Your Ref: EN010079  
Date: 7 June 2019

My Ref: 8/1/18/0088  
Tel No.: 01603 223231  
Email: john.r.shaw@norfolk.gov.uk

**Application by:- Norfolk Vanguard Limited for an Order Granting Development Consent for the Norfolk Vanguard Offshore Wind Farm Project.**

**Requested trenchless crossing of the B1149**

AIL deliveries to overrun hatched road markings and utilise full width of live carriageway lane.

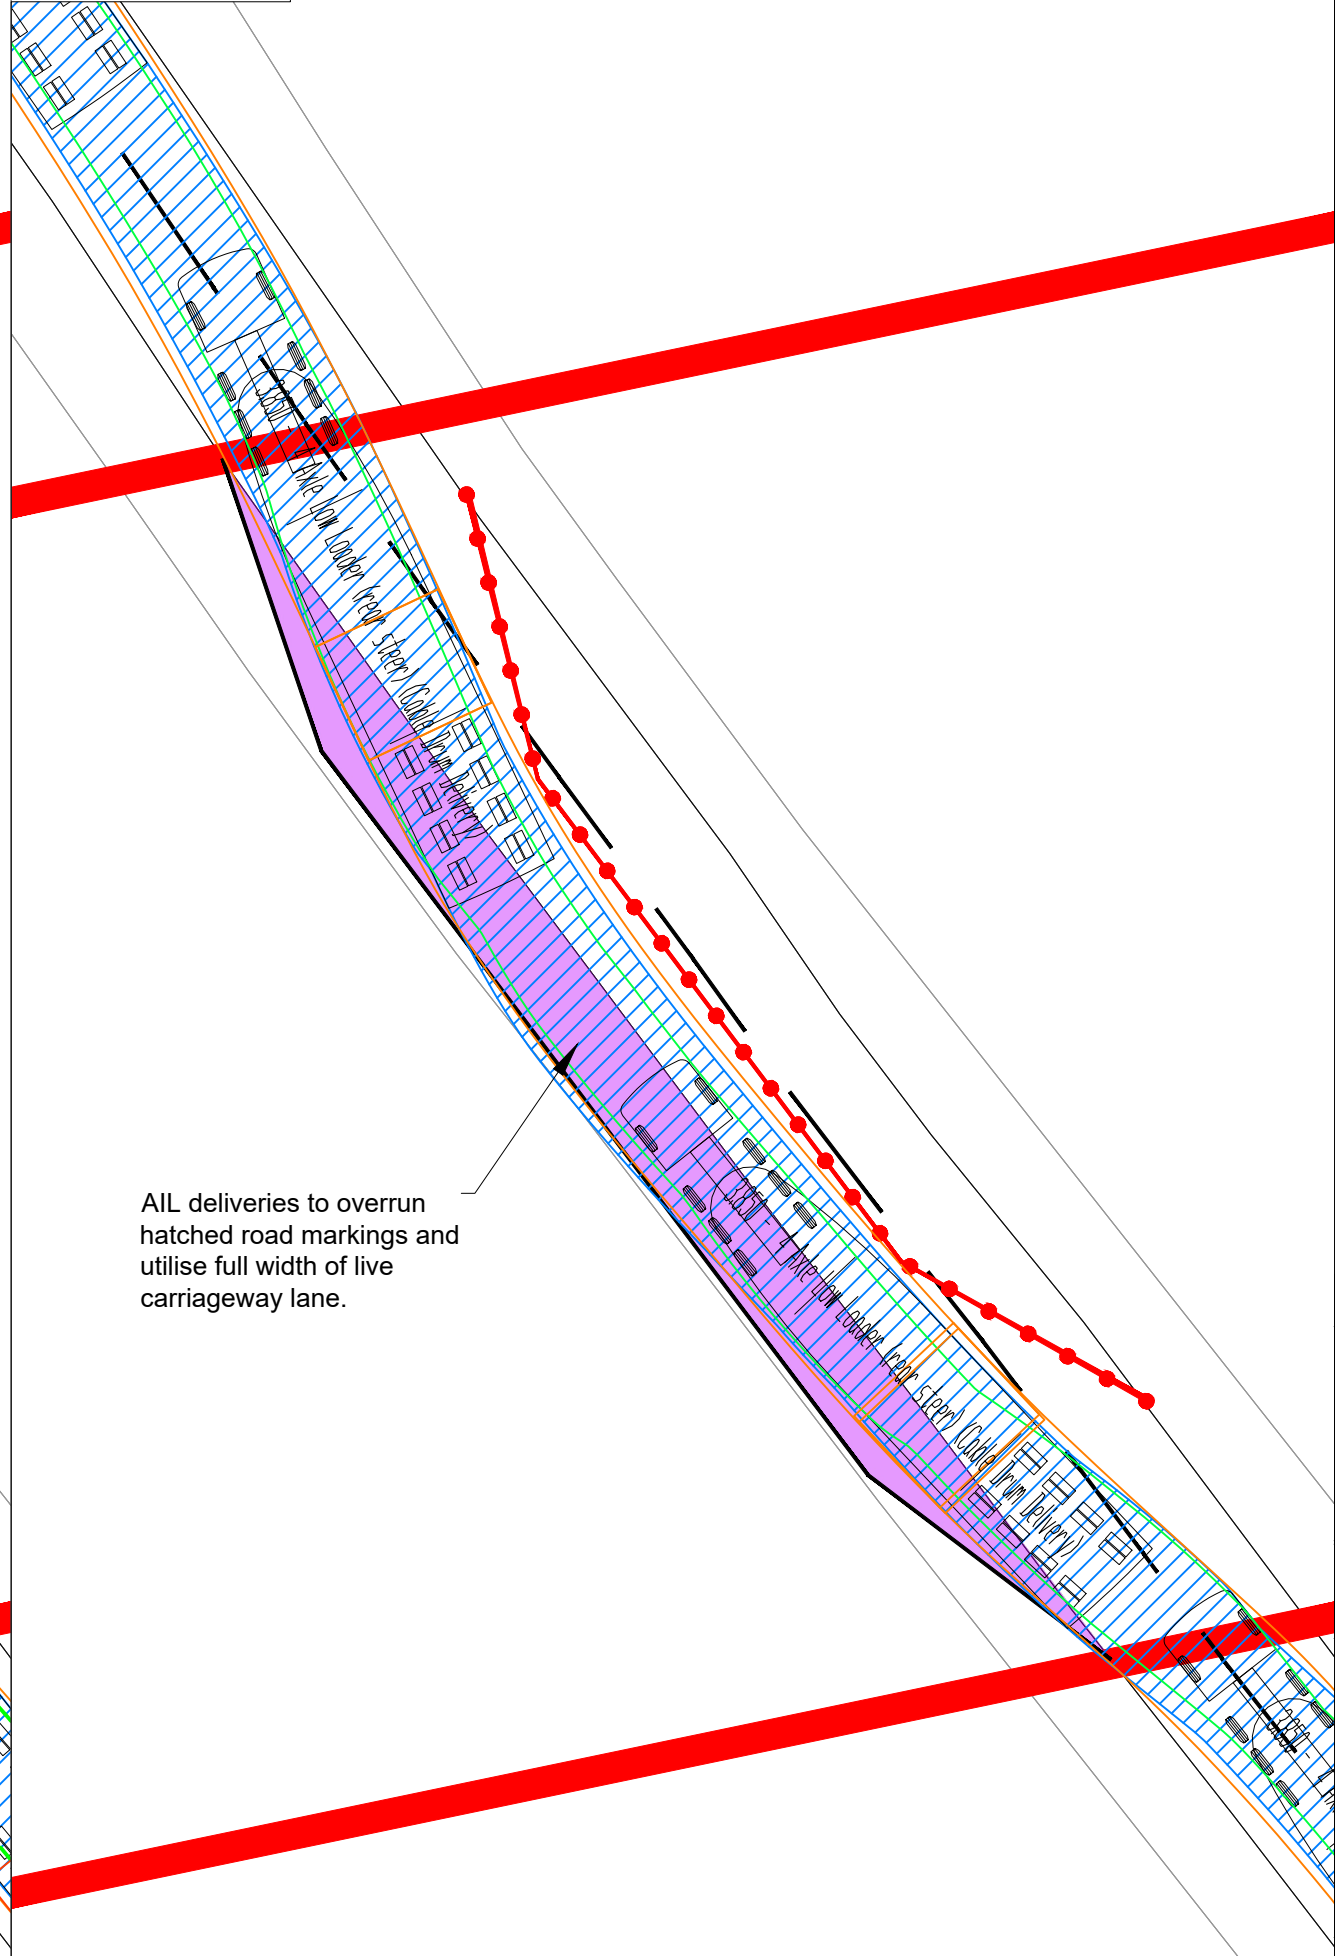
The applicants finally submitted a trenchless crossing report to the County Council on 15 May, which included details of the applicants proposed traffic management measures. The drawings attached to the report lacked detail and accordingly we subsequently asked the applicants to submit swept path drawings to demonstrate that Hornsea 3's vehicles would be able to negotiate the roadworks in safety.

Swept path drawings were submitted to us on 3 June and we responded on the 5<sup>th</sup> June to say the safety zone for the works was shown incorrectly and accordingly our concerns had not been addressed. **Contrary to the applicants claim within the position statement issued to you yesterday – the swept path drawings DO NOT in any way**

**demonstrate that the traffic management can be designed so that abnormal loads can physically negotiate the roadworks.**

- The safe working distance of 1.2m can be accommodated in the final design.  
In response, this is clearly not acceptable. There must be a realistic expectation that a safe method of working is achievable. That expectation has not been met.

- The proposed road widening (the pink land) can be widened further to the west within the order limits.  
In response – we fully accept that but widening to the west is not the problem we have identified. The problem lies to the north and south of the pink land and not to the west.

- The coned off area can be narrowed from 20m down to 15m.  
In response – we have not seen any details to show how that would work.
- Speed restrictions could be imposed  
In response – We have already advised the applicants (5<sup>th</sup> June) that whilst this can be reduced with the use of a temporary 30mph speed restriction, it is not so in the case of an excavation exceeding 1.2 metre in depth.

- The deep excavation can be designed to provide additional lateral support and thus ensuring a 0.5m distance of separation would be safe.  
In response – Construction work and road works carried out on public roads has to comply with Chapter 8 of the Traffic Signs Manual, which is aimed at reducing risk of harm to workers and the public. To comply with Chapter 8, deep excavations need a safe working area of 1.2m and not 0.5m as proposed.

- Norfolk County Council indicate within their position statement at 30.5.19 that land within the highway boundary, outside the Order limits, **would be available** to extend the tapers of the road widening if required, depending on the final design.  
In response – this is simply not true. The position statement says – “if additional land is required outside the pink land, then the applicant needs to demonstrate that they either have control of that land or that it forms part of the public highway.” To date they have not done either of these.

In the circumstances, the County Council remains of the view that trenchless crossing needs to be employed for the B1149 and that the requirement in the DCO needs to be amended accordingly.
